REQUEST

Current Zoning: UMUD(O) (Uptown Mixed-Use District, optional).
Proposed Zoning: UMUD(O) SPA (Uptown Mixed-Use District, optional, site plan amendment).

SUMMARY OF PETITION

The petition proposes a site plan amendment to petition 2010-065 to eliminate off-street parking requirements. The site is currently developed with a hotel.

TECHNICAL
DATA SHEET 3

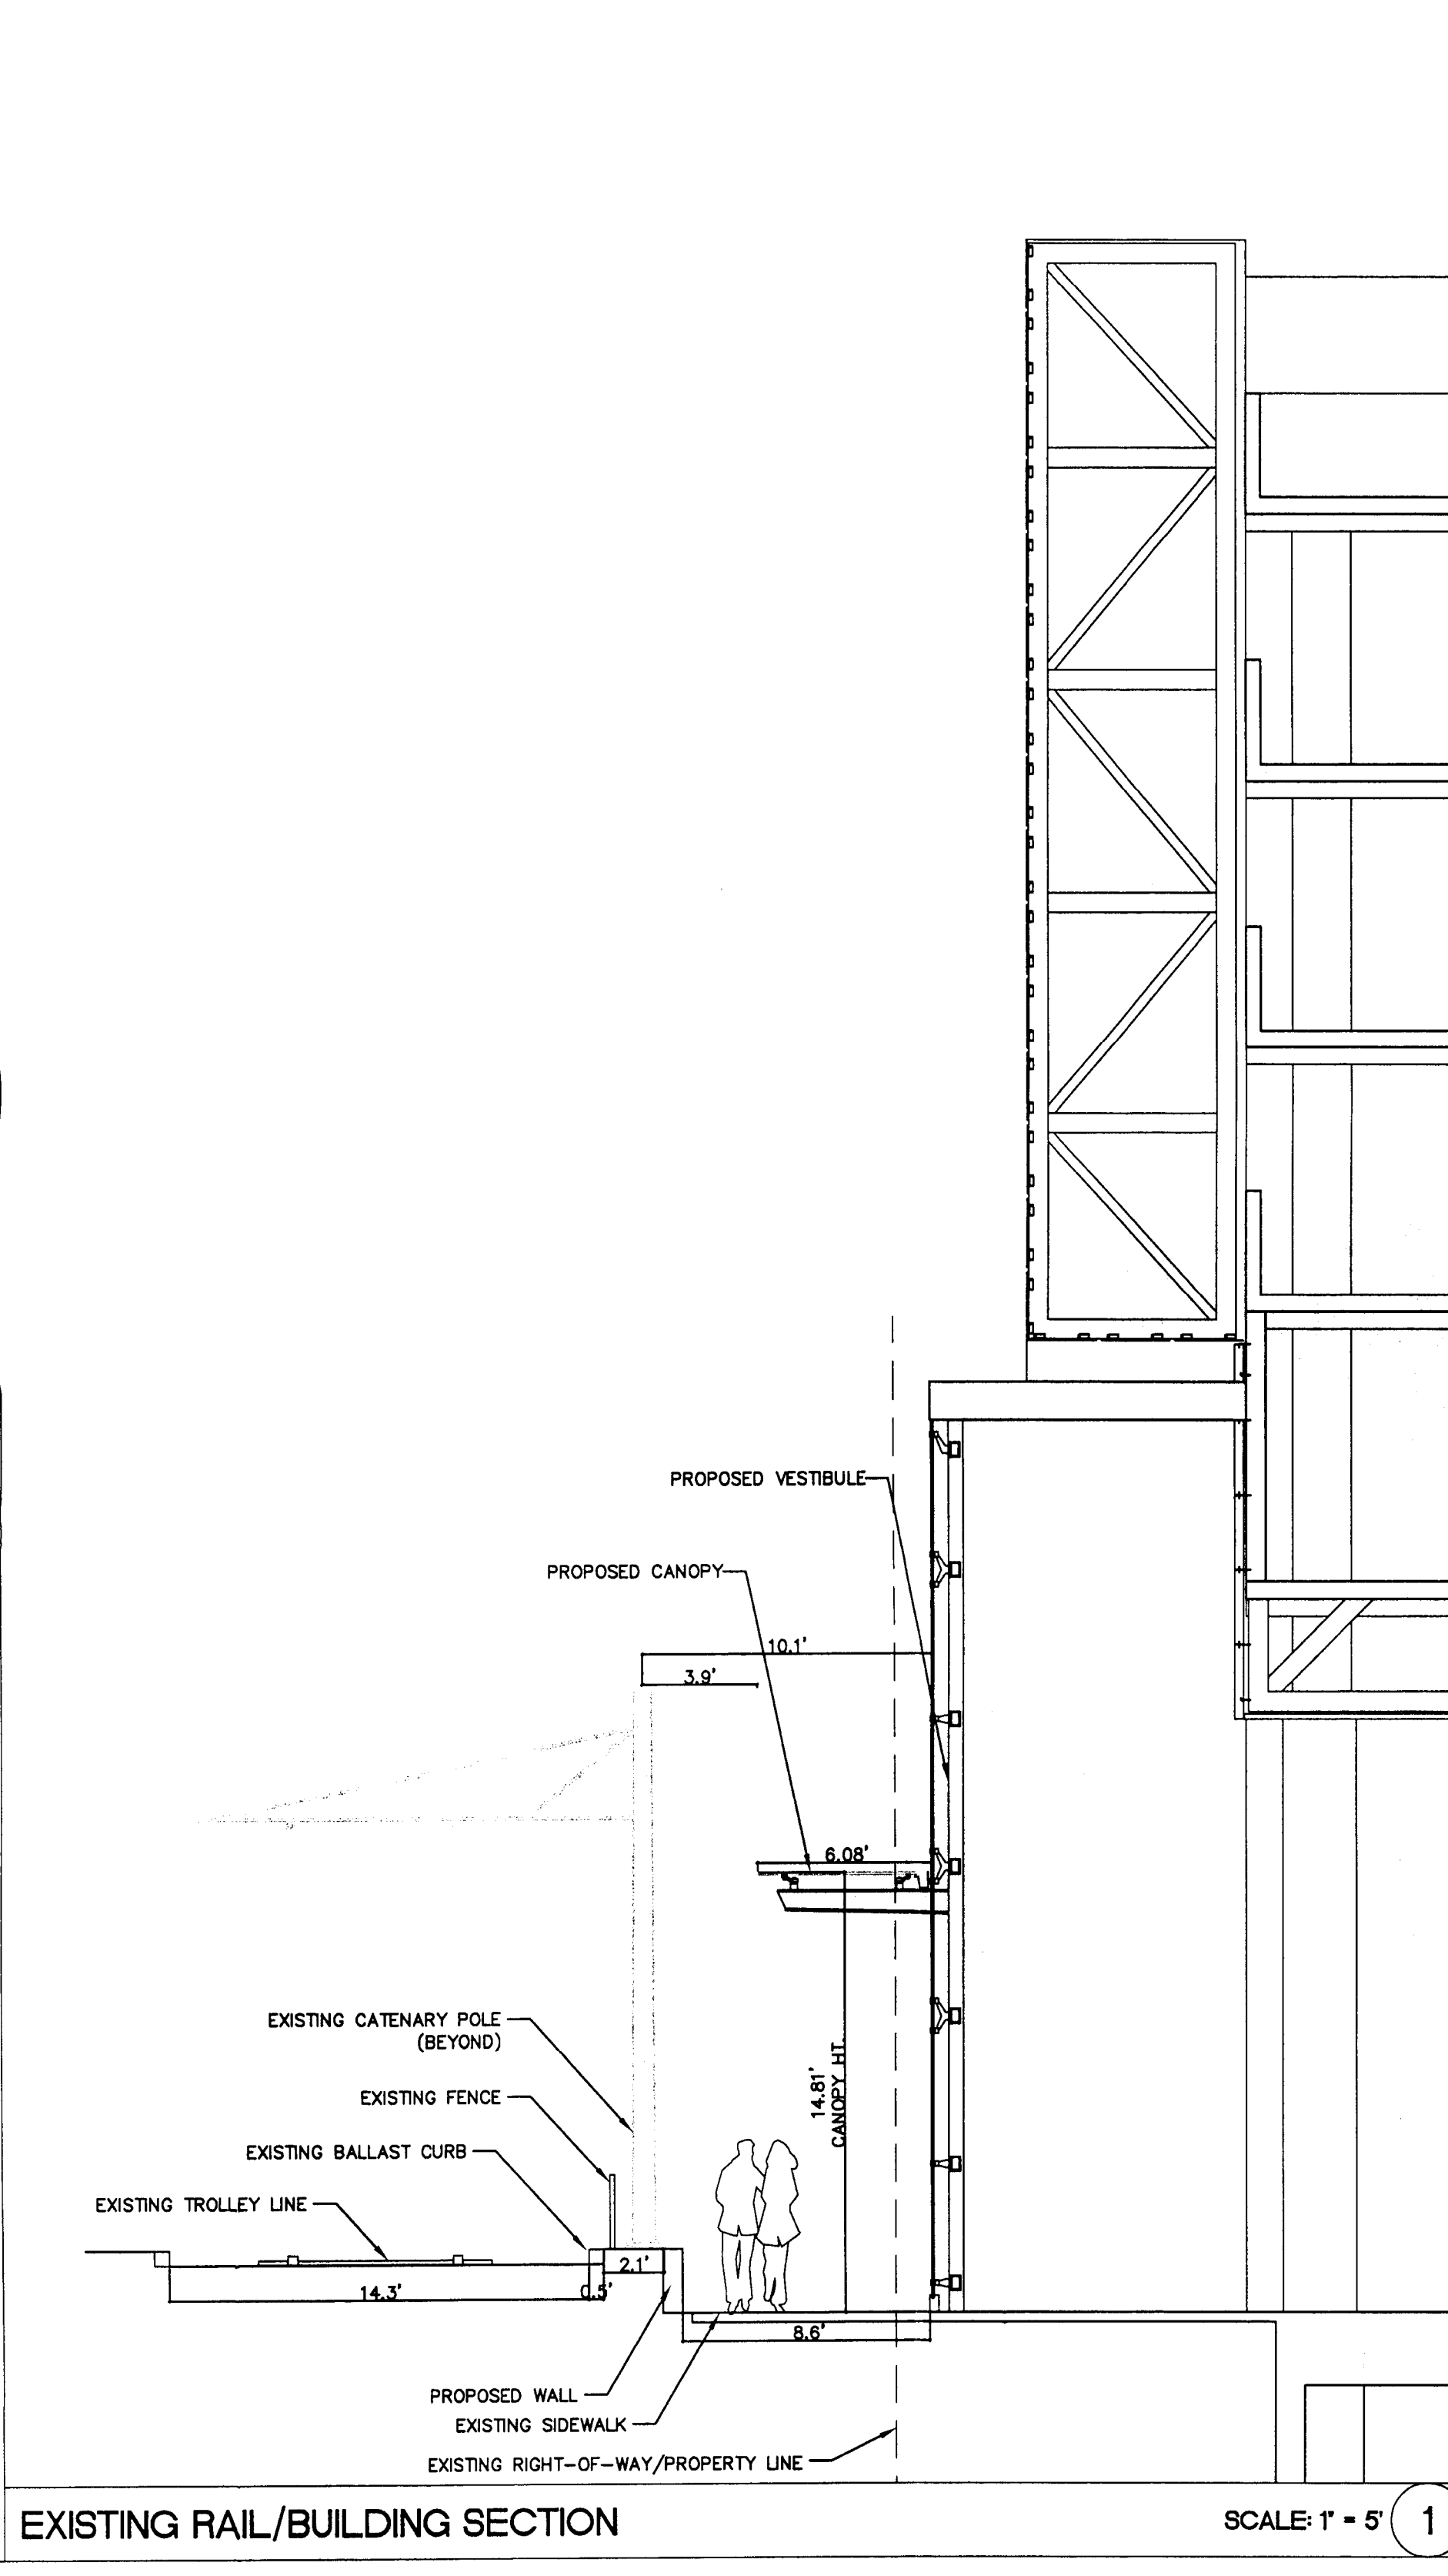
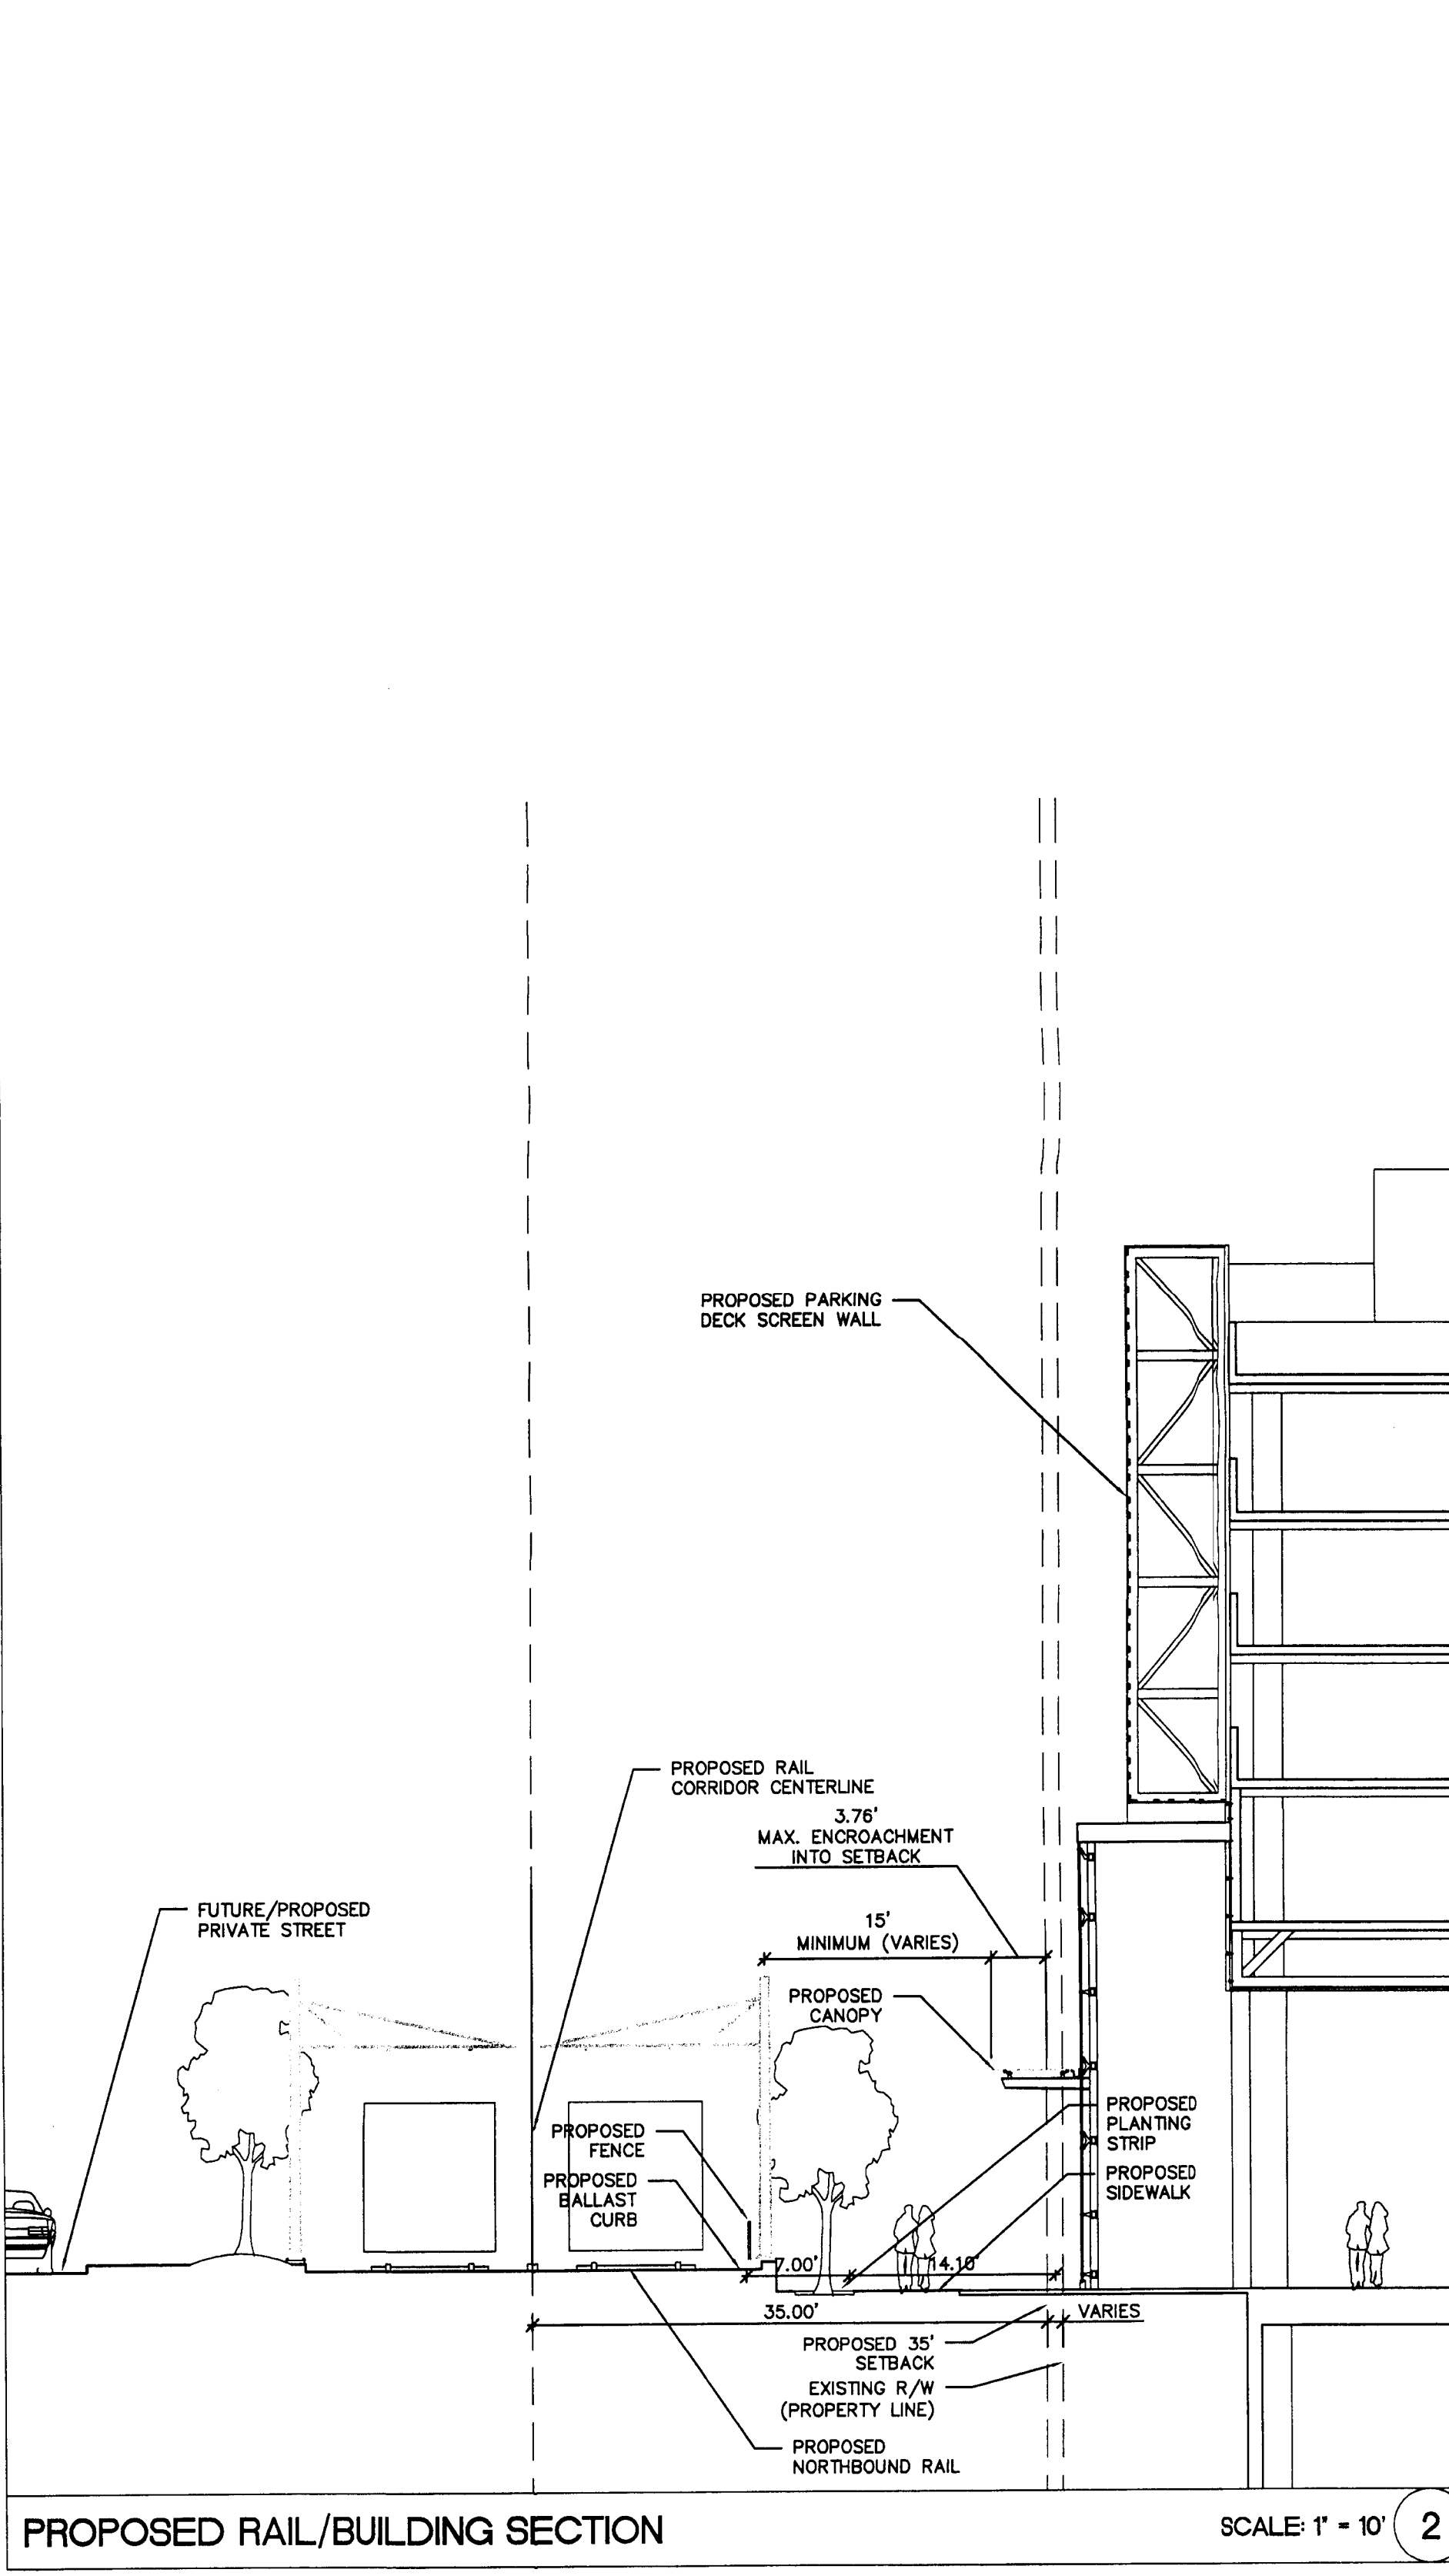
1. Entitlement Services: Add rezoning petition number to site plan.
-
